PROJECT NO. PR-2018-001579

Application No. SI-2021-00304 SITE PLAN, SI-2021-00305 SITE PLAN AMENDMENT, PS-2021-00040

SUBMITTAL DESCRIPTION: Based on the comments from the DRB Hearing March 31, 2021 we requested a deferral

RE: PR-2018-001579 – WINROCK TOWN CENTER
SI-2021-00304 SITE PLAN
SI-2021-00305 SITE PLAN AMENDMENT
PS-2021-00040 SKETCH PLAT

PROPOSED ROAD-E

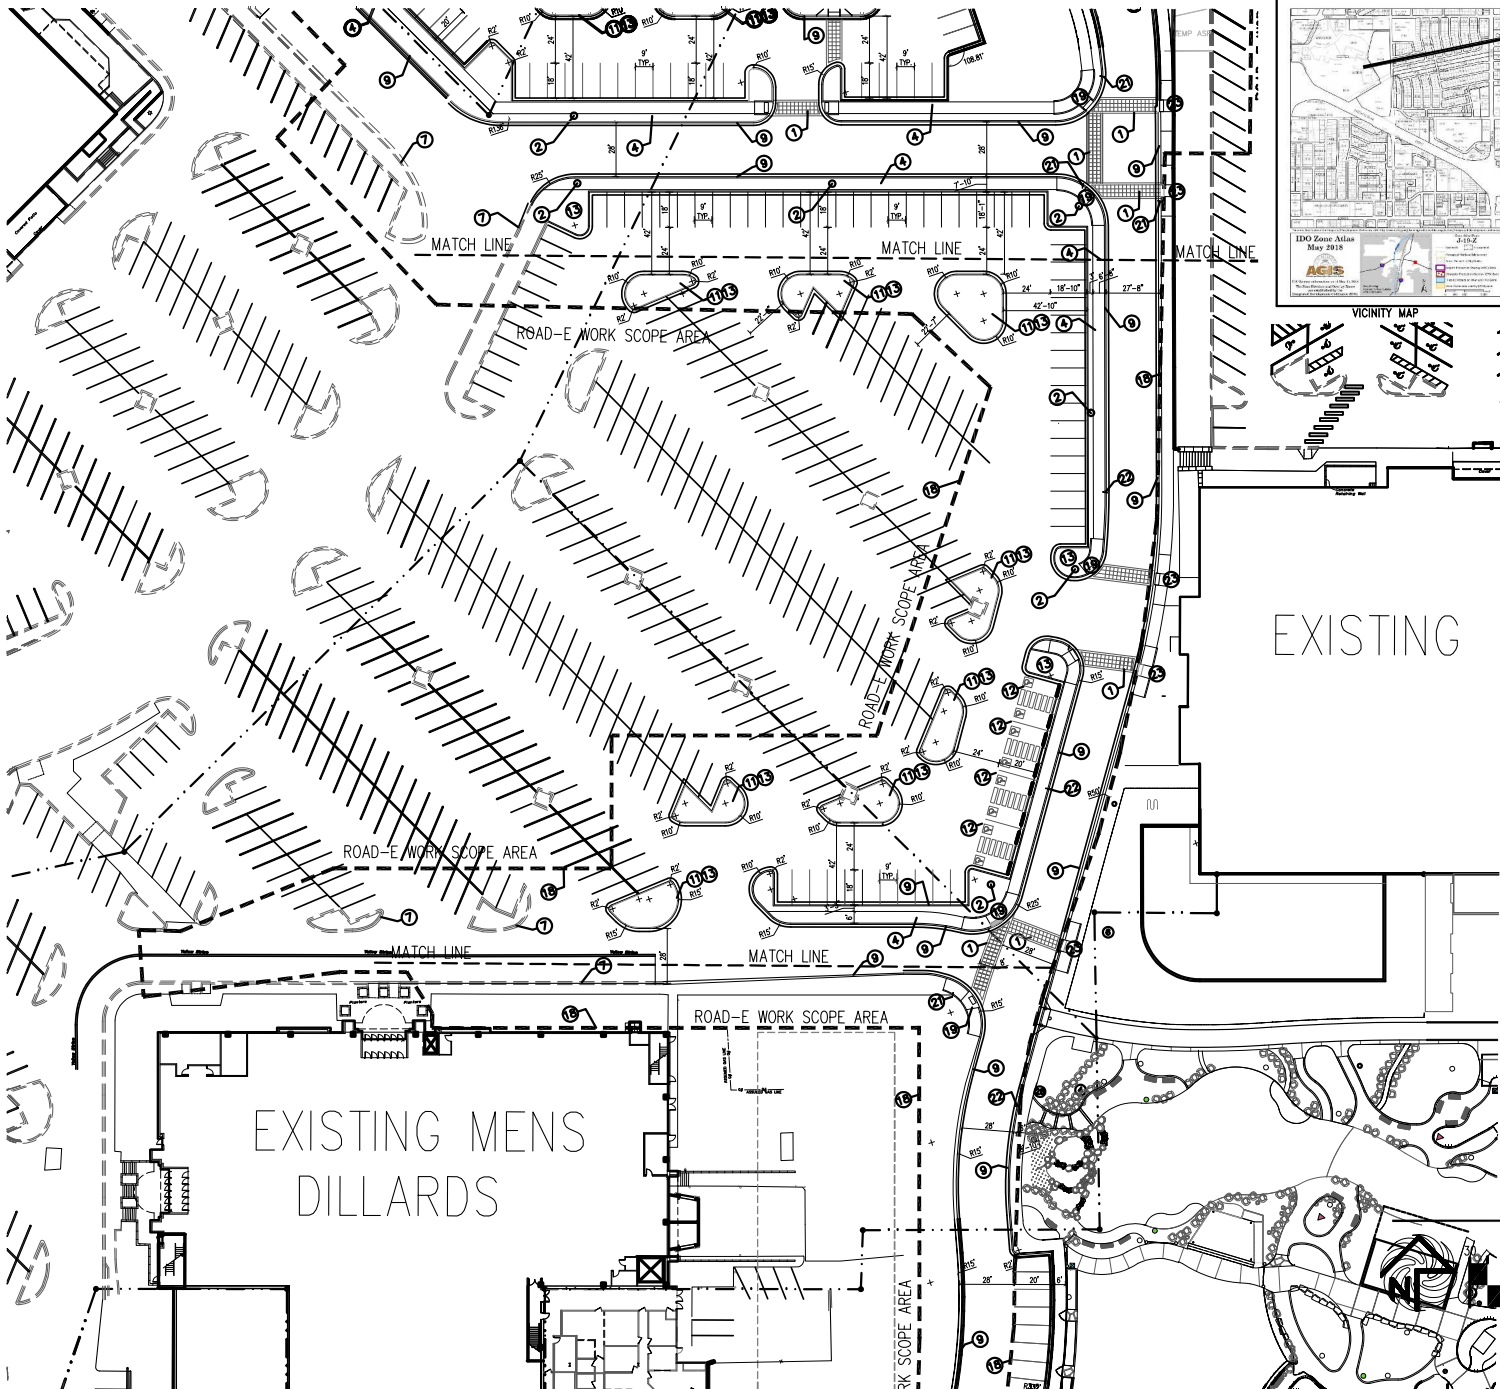
4. Provide a layout of Roadway E that is shown on infrastructure list and show a cross-section. Who will maintain Roadway E as this impacts accurate infrastructure requirements?

5. Provide proposed traffic control at intersection at the southwest corner and indicate any stop signage and pedestrian signage. Also label all other signage such as handicapped signage and motorcycle signage on the site plan.

Applicant Response: Roadway E is same as Roadway B and shall be within a public roadway easement.

Applicant Response: A site specific plan for Roadway E has been submitted with this application

DATE: 1/14/22  
 AS NOTED: C200

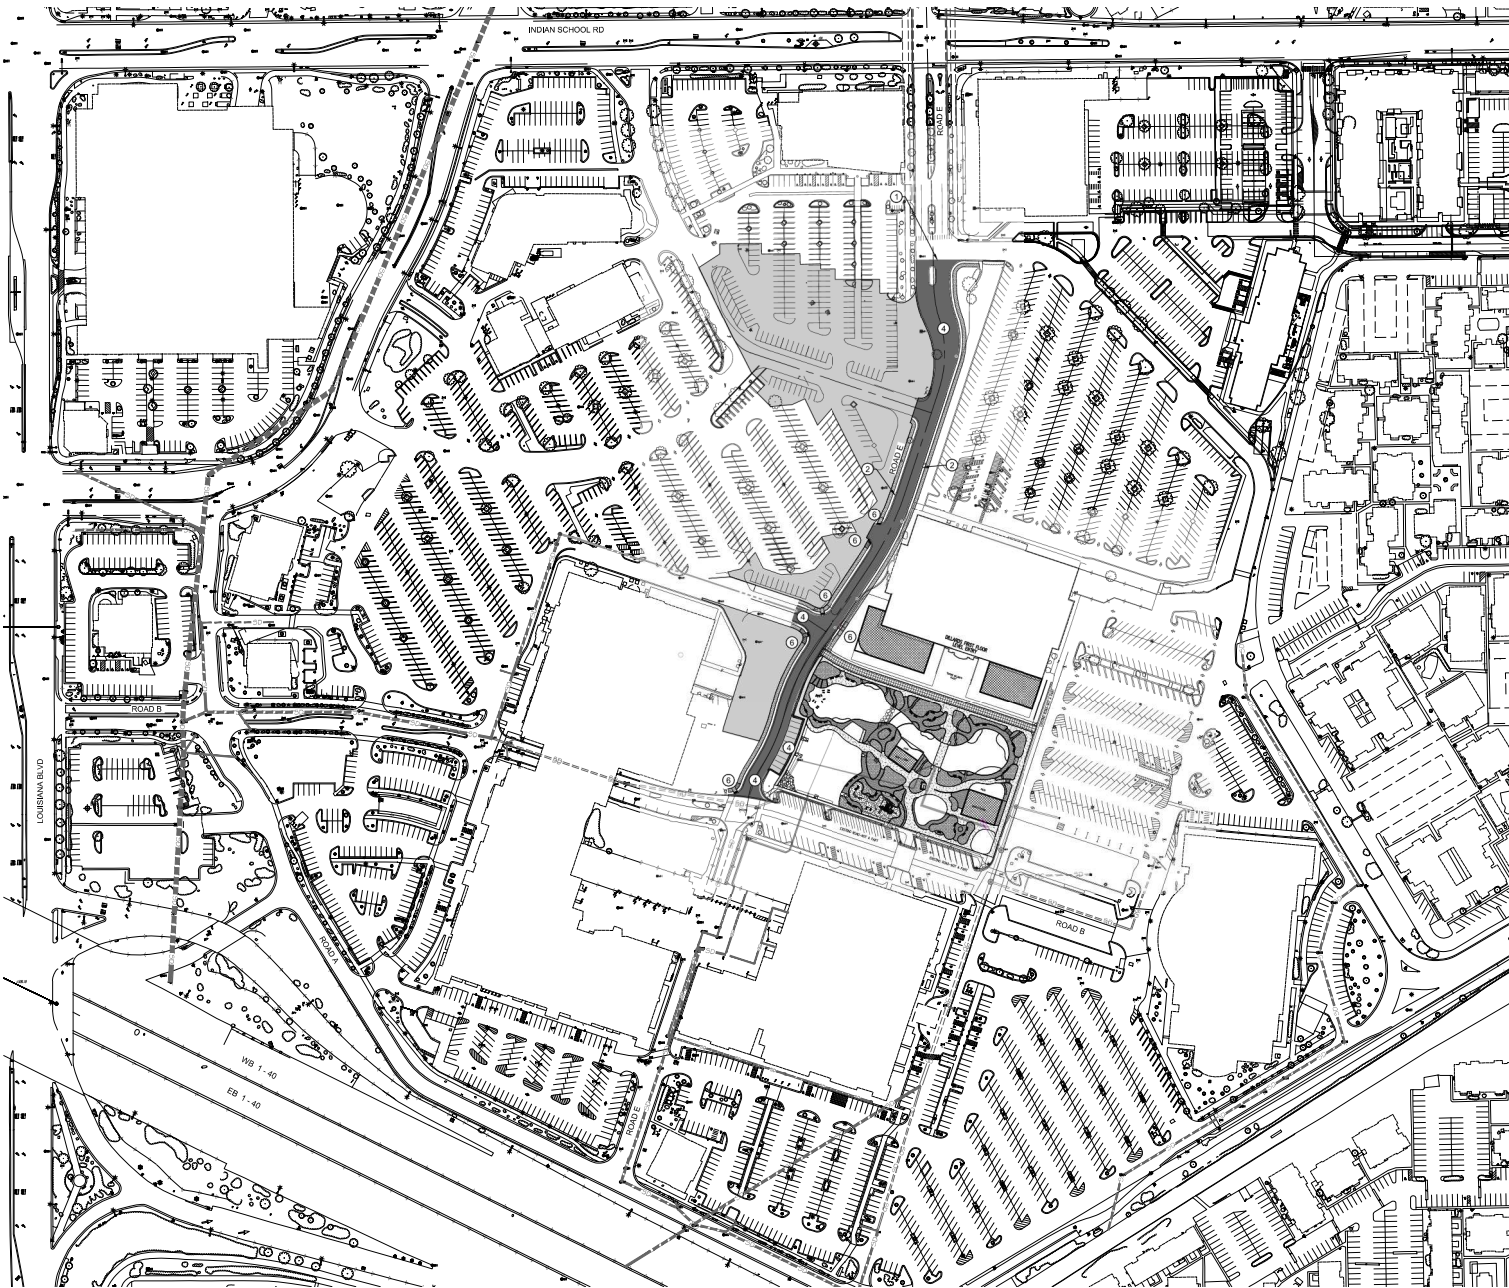
- b. Site Plan
 - i. Please add a master utility plan to provide context for the utility plan for this site.

- iii. Show the water and sewer easements on the utility plan.

- iv. Please dimension the distance between each type of utility on the utility plan.

- v. Please correct the callout for "4" on the northeast side which appears to depict an existing line to be removed.

- ix. Please be advised that encroachments shall not be constructed over the reuse water line. Please review the alignment of the reuse line. Can this line run due north similar to the water and sewer mains?

Applicant Response: Master Utility Plan Included with resubmittal.

Applicant Response: Public and Sanitary Sewer easements shall be shown and dimensioned on upcoming revised utility plans.

Applicant Response: Public and Sanitary Sewer easements shall be shown and dimensioned on upcoming revised utility plans.

Applicant Response: Updated.

Applicant Response: Utilities have been realigned.

# APPLICABLE EASEMENT EXHIBIT

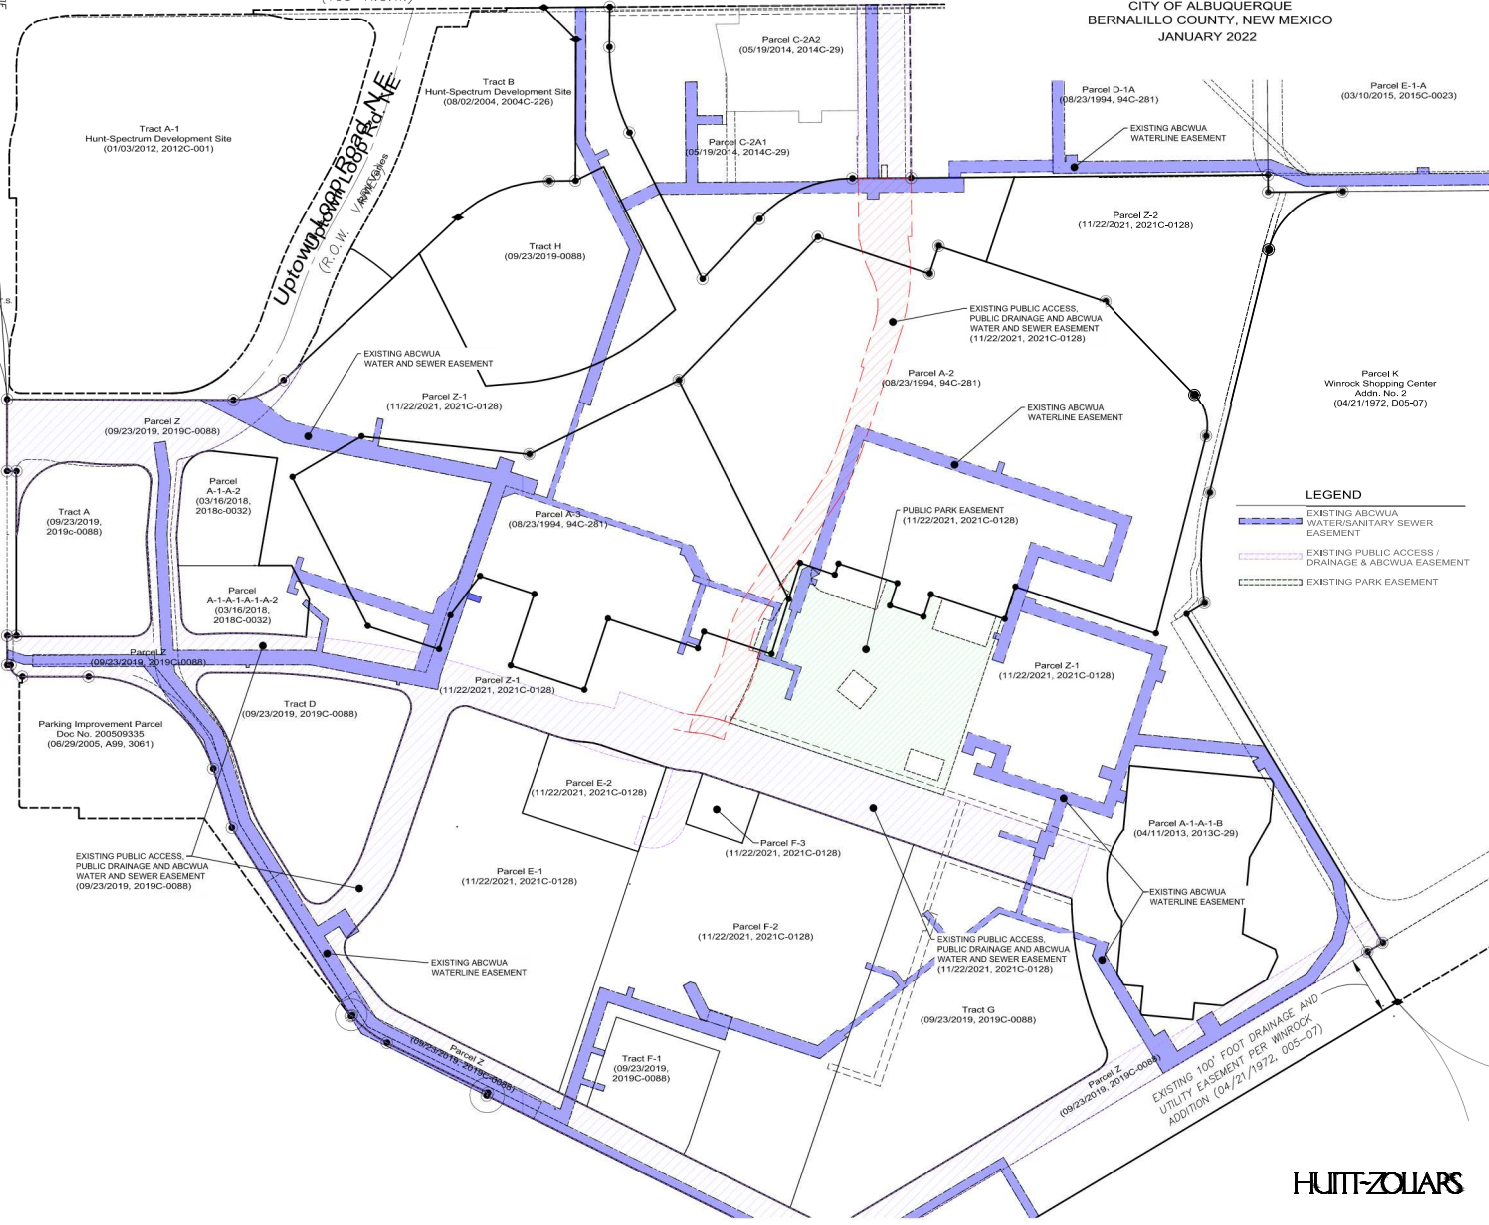
- viii. Please demonstrate sufficient easements for the proposed reuse lines, and any other public water and public sewer lines not currently within easements. The easement map provided with the plat does not appear to show easements for all the public lines, in particular the reuse running through the park and the initial sewer connection to existing manhole.

Applicant Response: Additional Easement Exhibit shall be provided.

# EX. PLAT & SITE PLAN OVERLAY WINROCK CENTER ADDITION

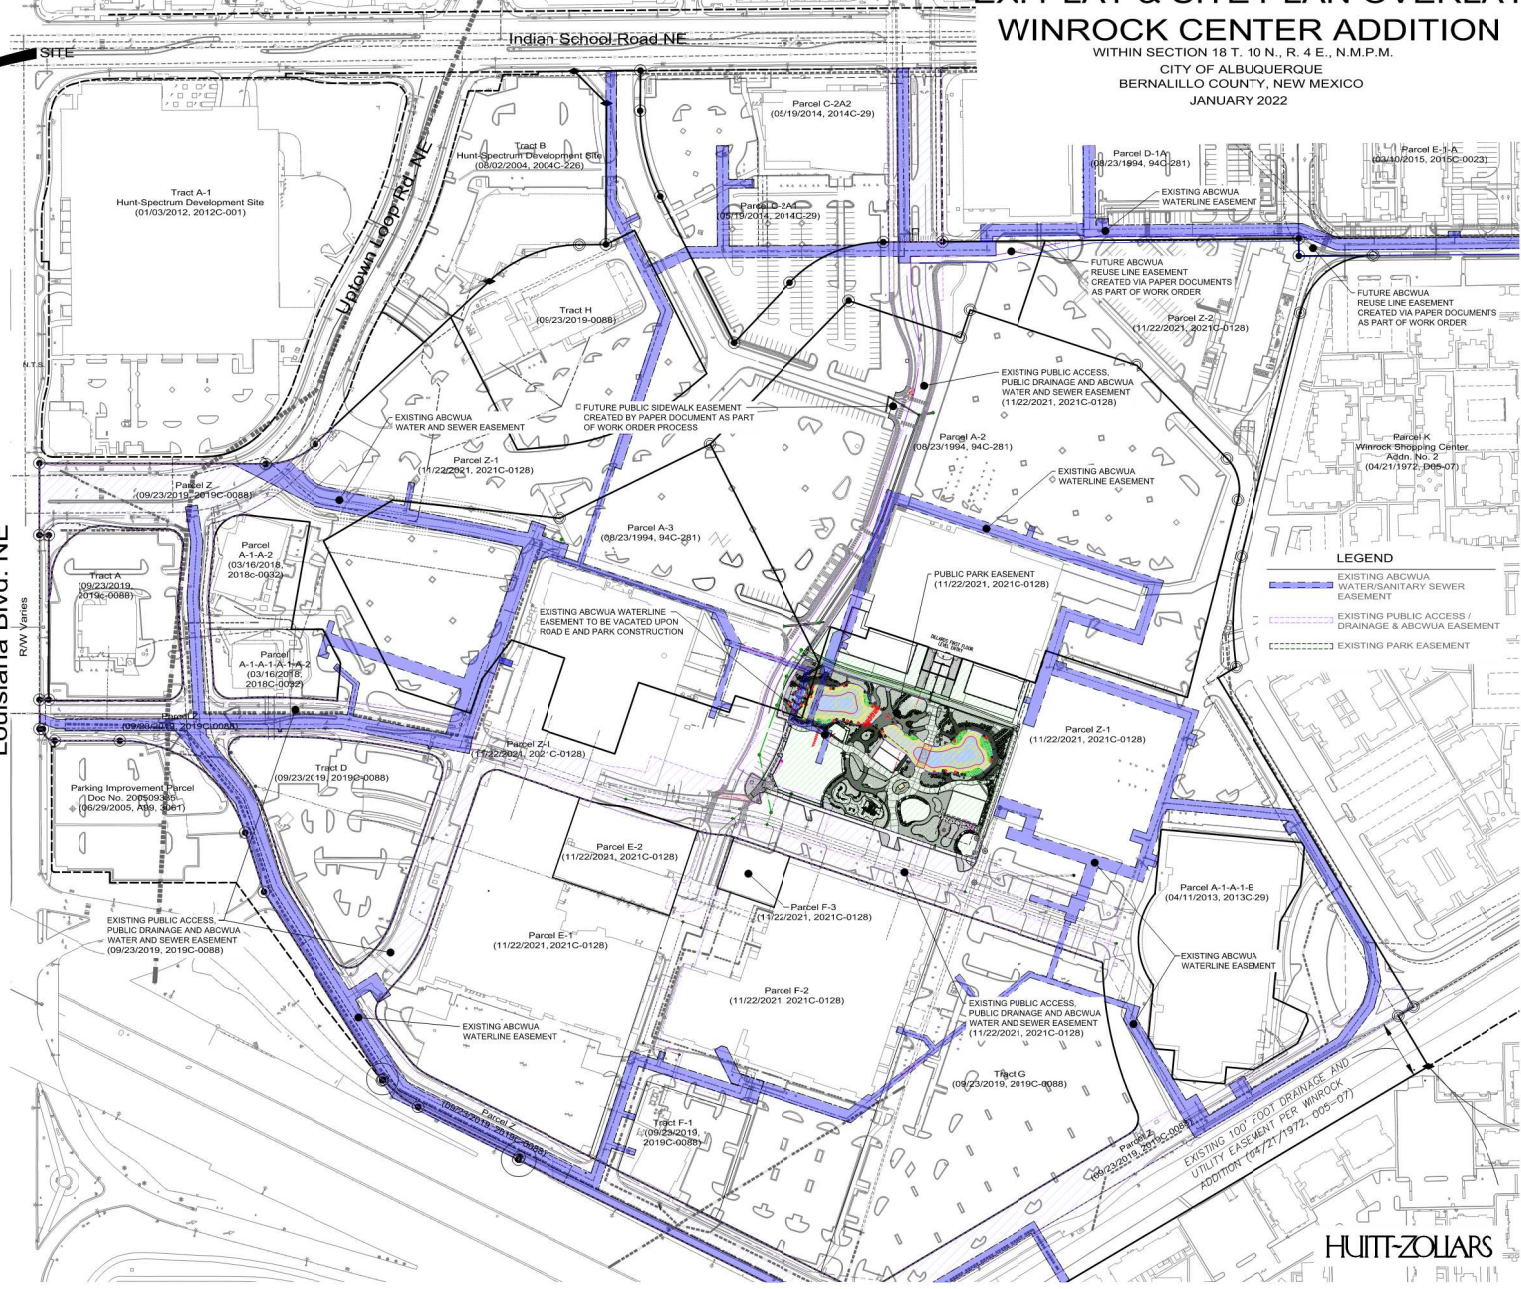
1. Any required platting action shall occur prior to the site plan approval; update shared parking/access establishments as necessary. With the new plat, overlay site plan with new site plan adjustments to make sure boundary lines are set appropriately. For the plat, also show surrounding public sidewalks (both existing and proposed) to ensure these are within right-of-way.

Applicant Response: Plat submittal shall follow completion of SI-2020-1477 & SD-2021-00035 platting action.
